From: [REDACTED]
Sent: 04 July 2025 16:21
To: Planning
Subject: Planning application No. 3/2025/0460

Formal Objection to Planning Application for Change of Land Use at 38 George Lane, Read, BB12 7RH. Hammond Ground 3/2025/0460

sheet: os plan

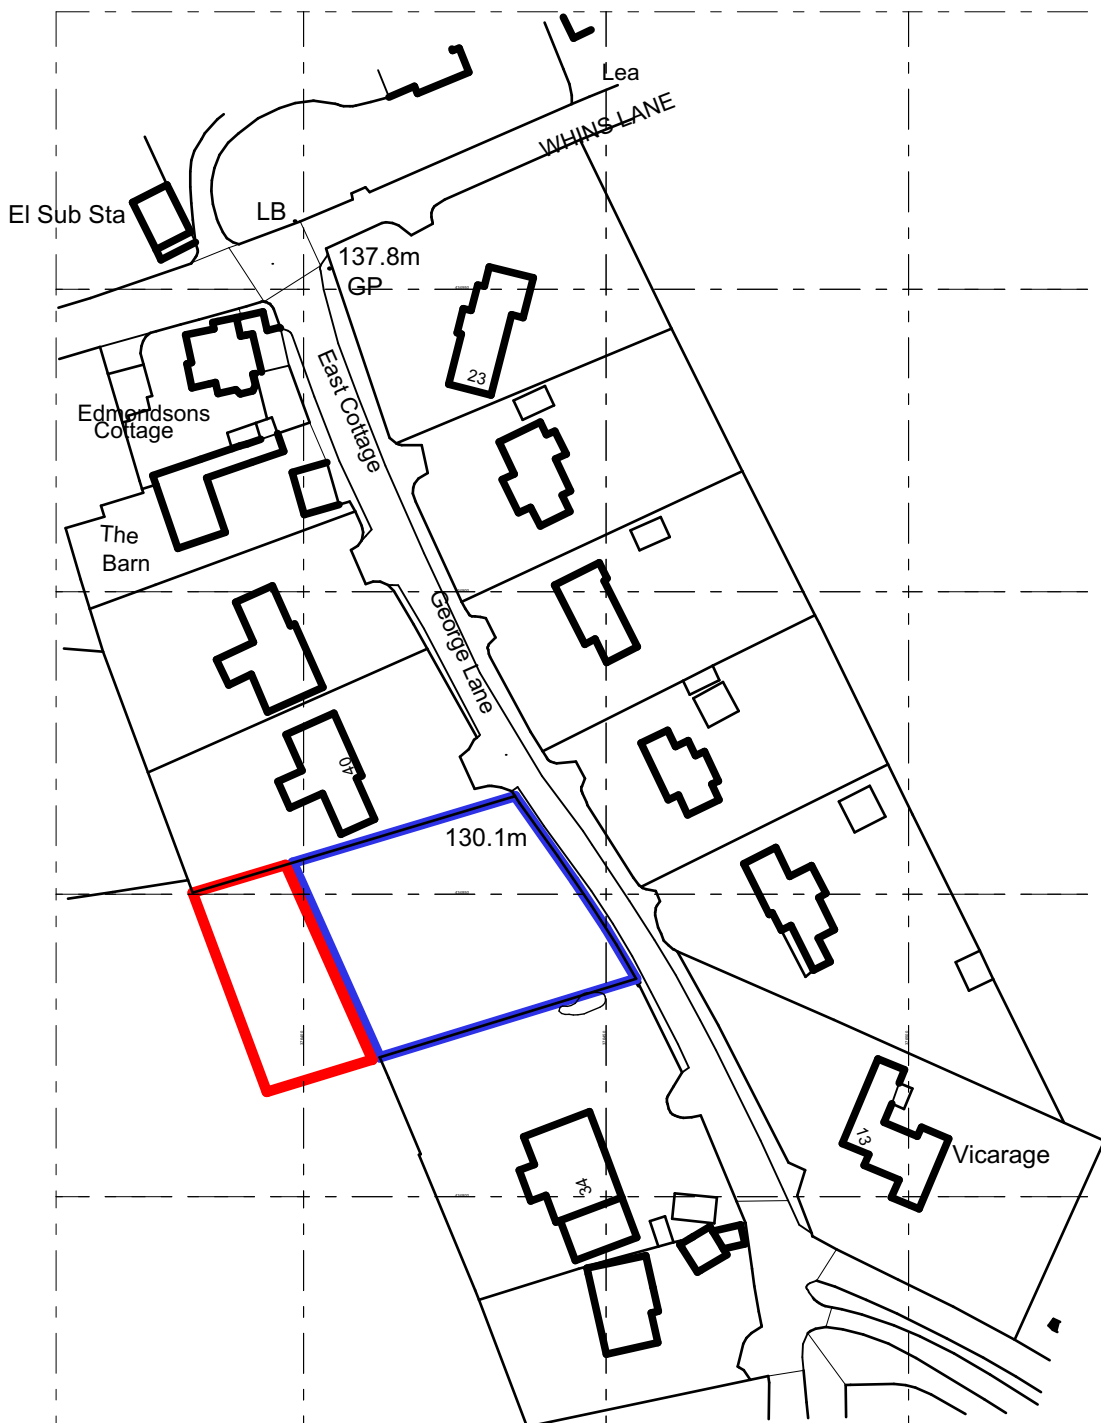
The location map misinterprets the adjacent housing showing it aligning the garden with other houses to the north of George Lane. These houses do not back onto the field of Hammond Ground. If the map showed all the other many houses running south further down the lane you would see that all the gardens do not extend into Hammond Ground. My understanding is these current boundaries mark the parish boundary.

proposed site plan

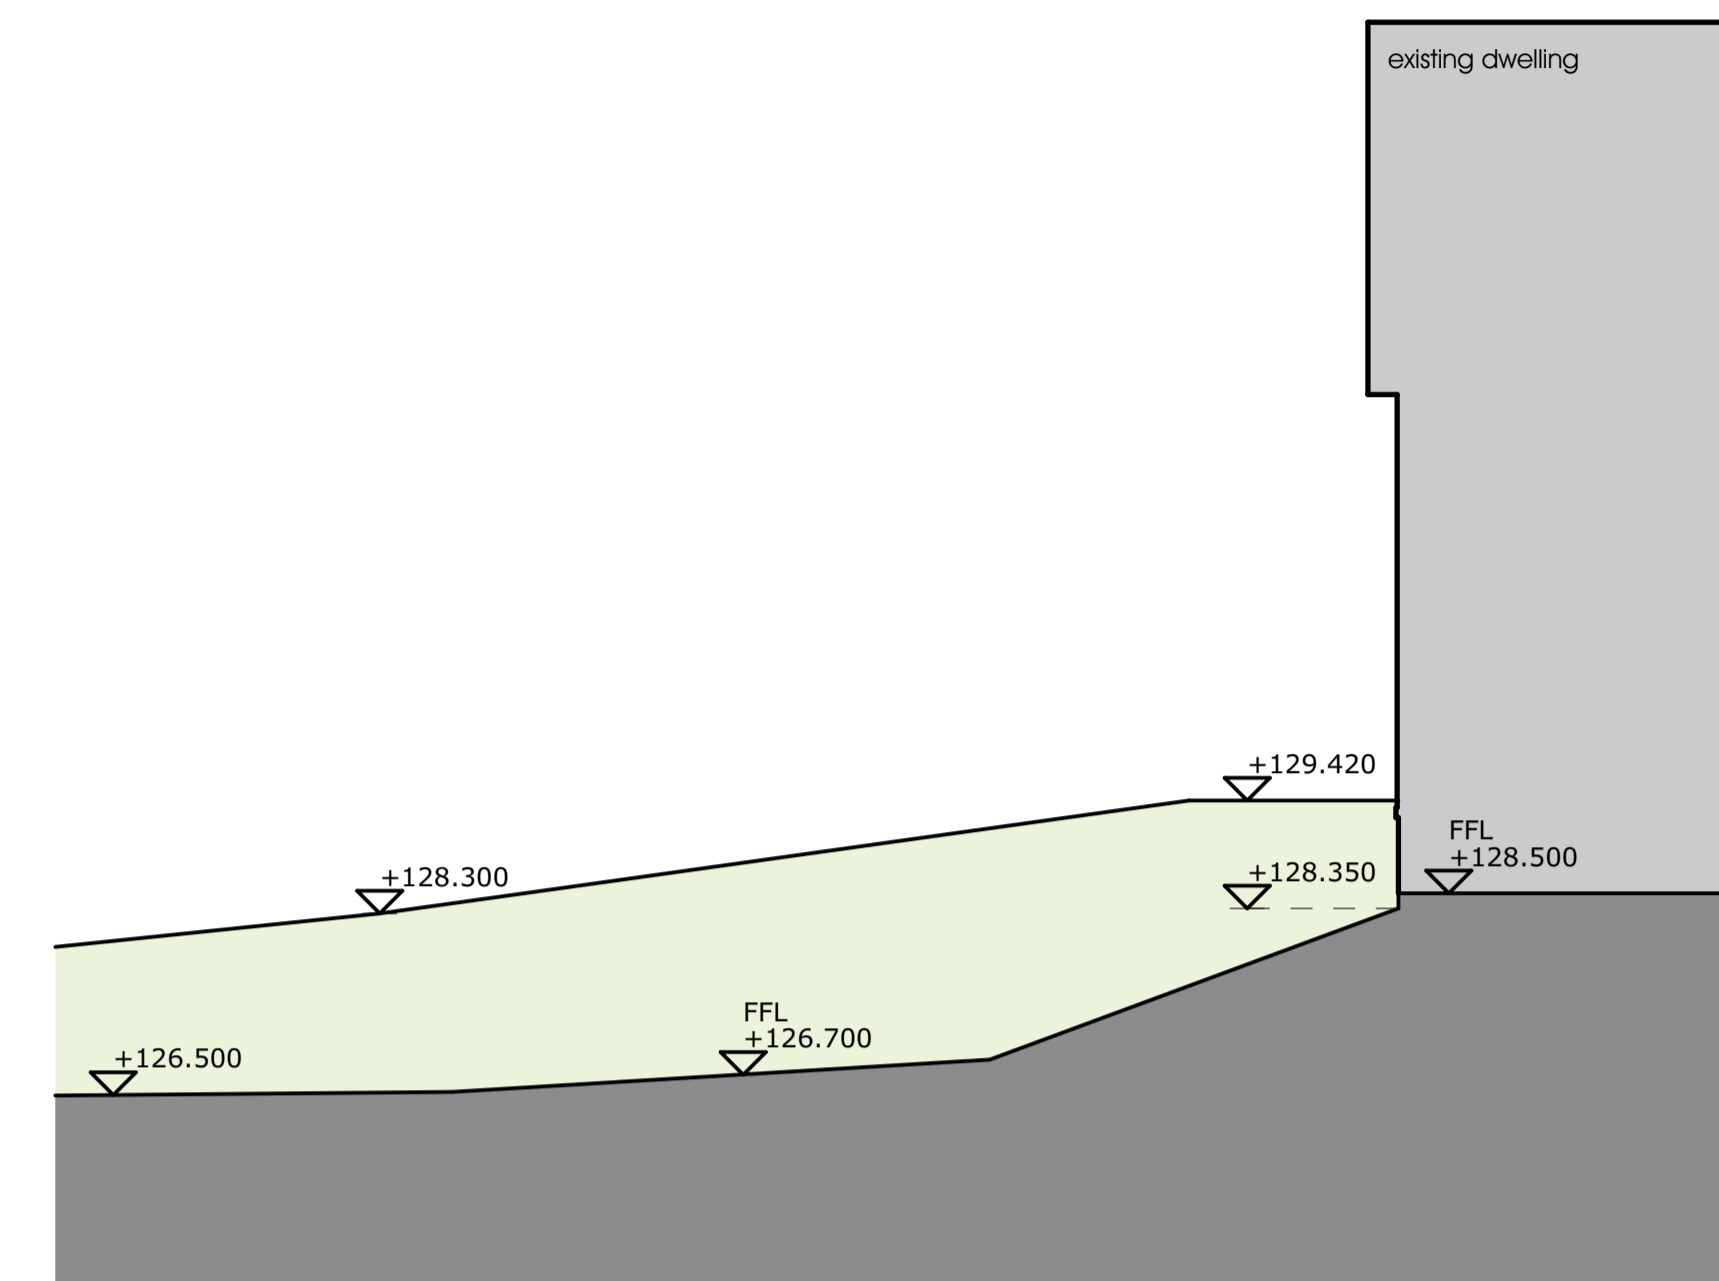
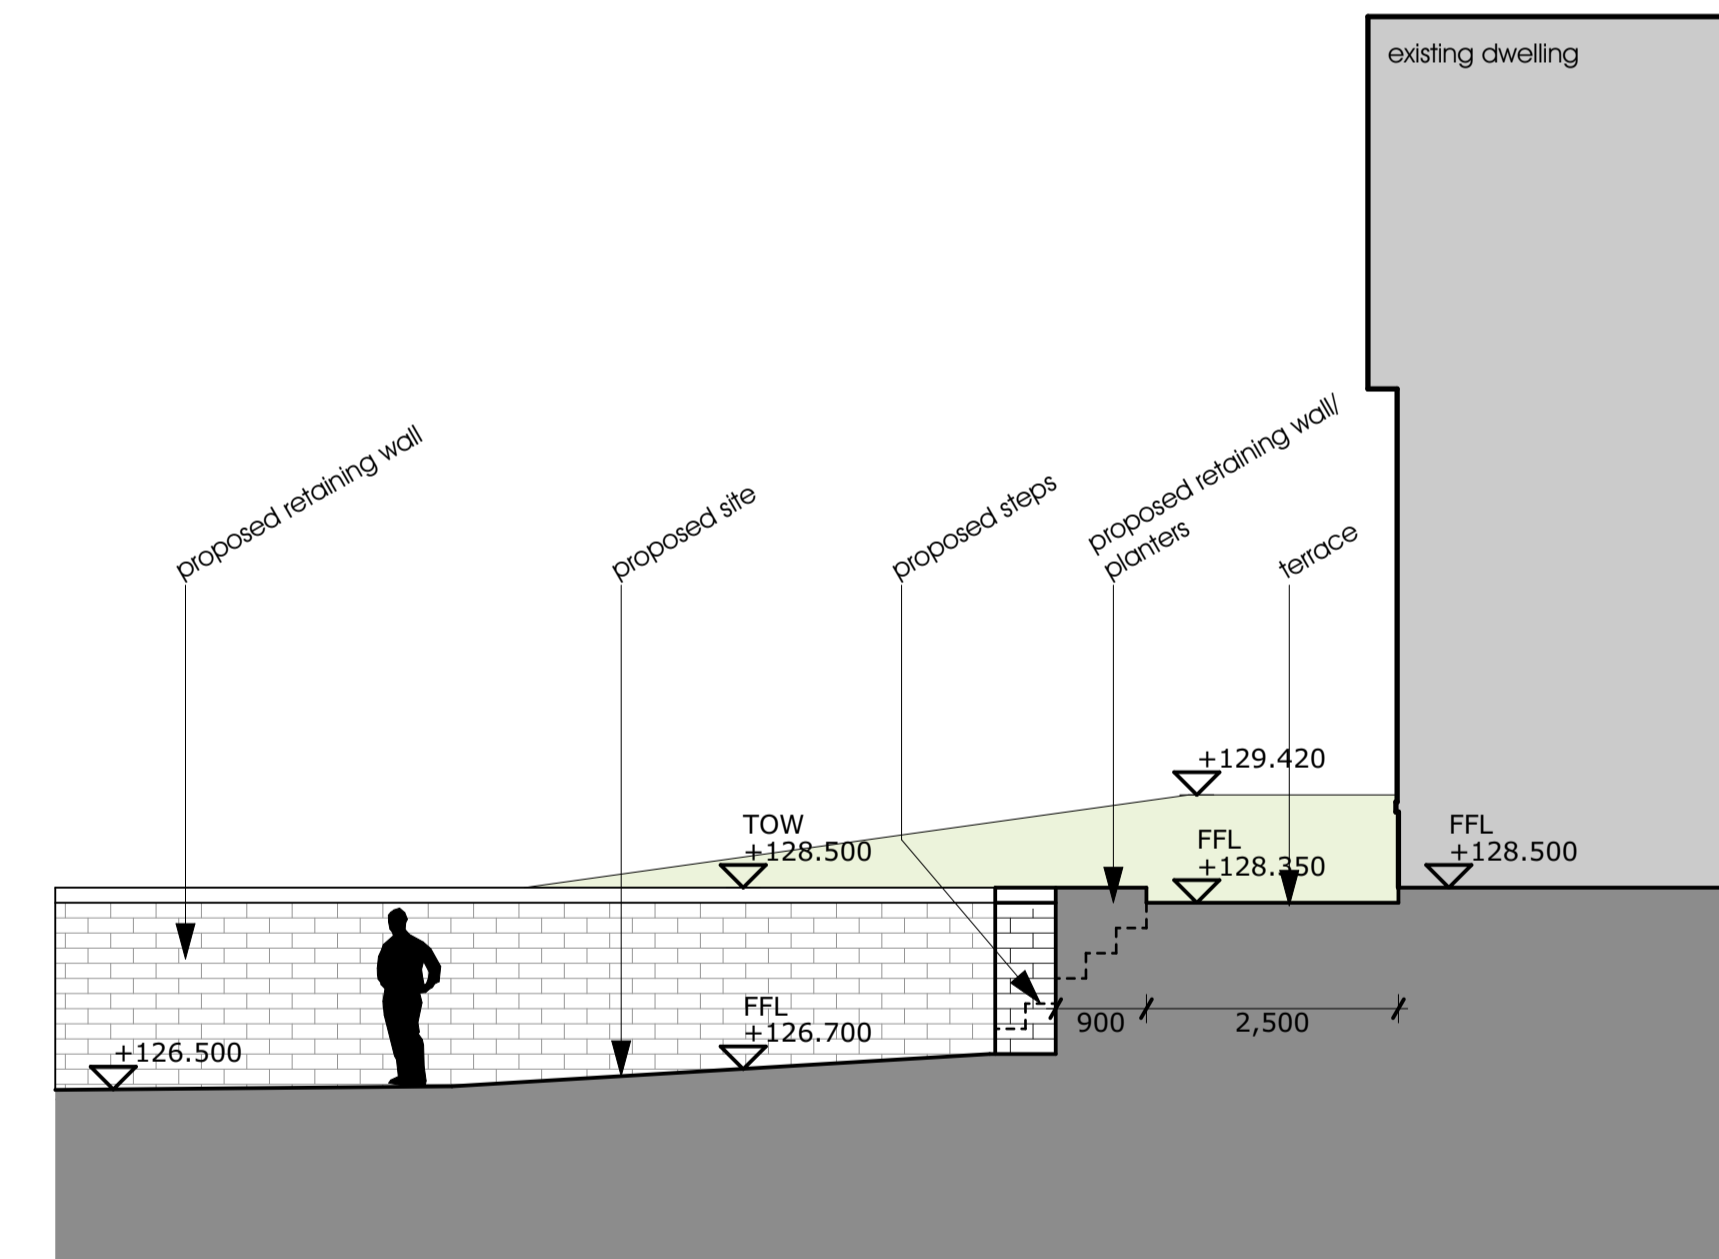
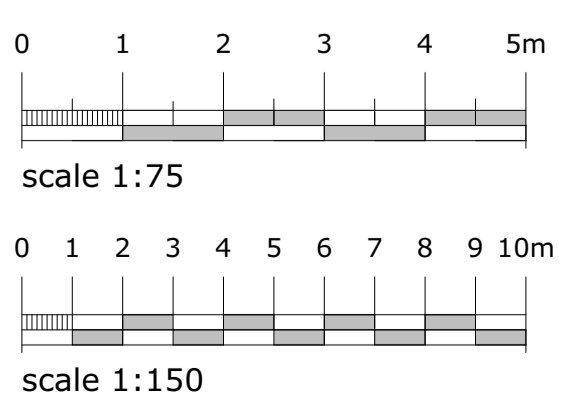
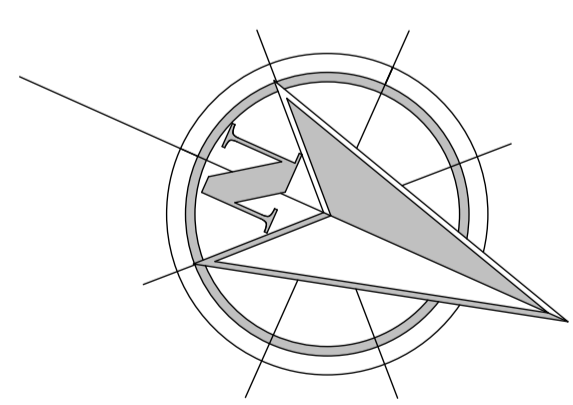
Original planning for the property was approved on the grounds that United Utilities, in supplying the main feed of water for the village through the plot, would always have free and immediate access. I fail to see how this could be achieved with hard landscaping built above the pipe itself. I am also concerned that you have not identified United Utilities as part of the consultation process given the importance of the supply to the village and any potential impacts as it runs directly through the plot.
